Date: 9 January 2026

SEA LINK DCO APPLICATION (EN020026)

**SCC PRINCIPAL AREAS OF DISAGREEMENT SUMMARY STATEMENT
(PADSS)**

Plate 2.1 Section of Benhall Bridge

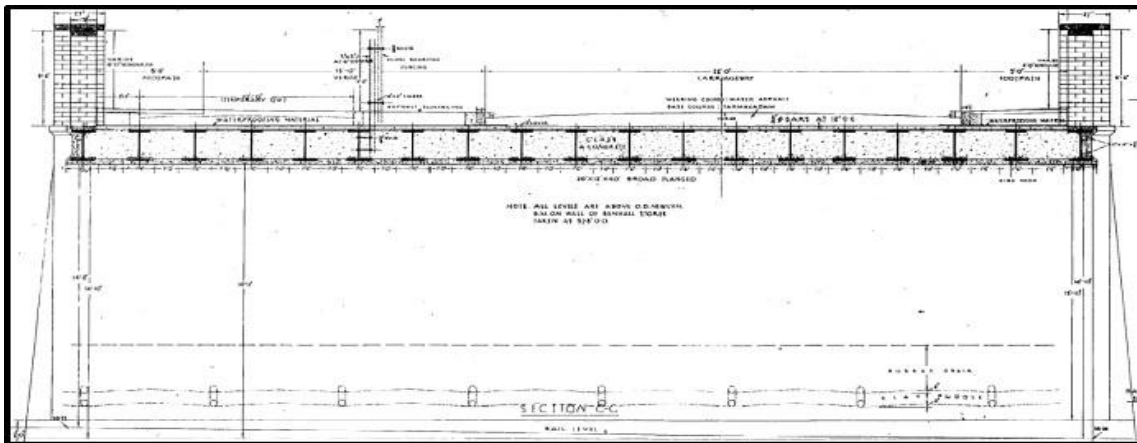
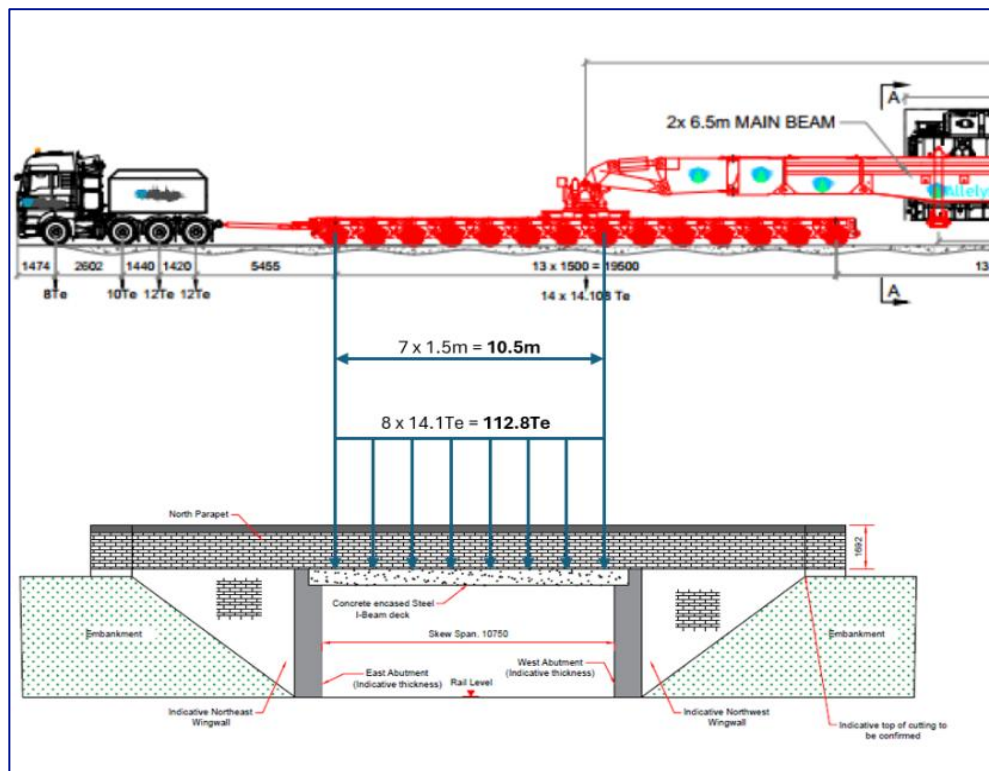
1.2	Use of Benhall Railway Bridge, B1121	Significant concerns relating to the proposed use of the Benhall Railway Bridge, B1121, a Council asset which, due to its structural condition, has a weight restriction of 46 tonnes (STGO 1). The Applicant has	As per the current access route, the railway bridge would form critical infrastructure to deliver the Sea Link scheme, therefore joint engagement with all relevant stakeholders is required, including Suffolk County	Not known at this stage.

Item	Area of Concern	Explanation	Remedy Item	Likelihood of Resolution
		<p>proposed overbridging for Abnormal Indivisible Loads (AIL) movements, however due to the geometry of the bridge and its proximity to the A12, the Council has concerns over the feasibility of this solution. Concerns include impacts of disruption whilst works are ongoing, including greater levels of traffic due to diversion through Saxmundham and A12/B1119 Rendham junction, lack of evidence on total number of movements that exceed the current weight limit, coordination of bridge closures with traffic related to other NSIPs in the area including Sizewell C and Scottish Power Renewables projects (SPR), lack of detail on temporary traffic management to mitigate impacts of work relating to the bridge.</p> <p>See A1.1 & A5.1 of [REP2-062] and Chapter 11 of [REP1-130] such as paras 11.222 to 11.229 for further details.</p>	<p>Council (as asset owner) and Network Rail (due to the interaction with the East Suffolk Line).</p> <p>Suffolk County Council and East Suffolk Council requested an in-person meeting to attempt to resolve outstanding highways matters, which was held in early August 2025.</p> <p>The Applicant did share further information on their approach to the overbridge but the Council as Local Highways Authority would still need to review the options put forward.</p> <p>The Council considers that there has been a lack of exploration of alternatives such as provision in the Order Limits for installation of a new nearby bridge. A lack of detail has been provided at this stage to demonstrate the feasibility of the mini-bridge and bridge repair options including information on what adverse effects will be experienced by residents of the nearby Whitearch caravan park and how their access,</p>
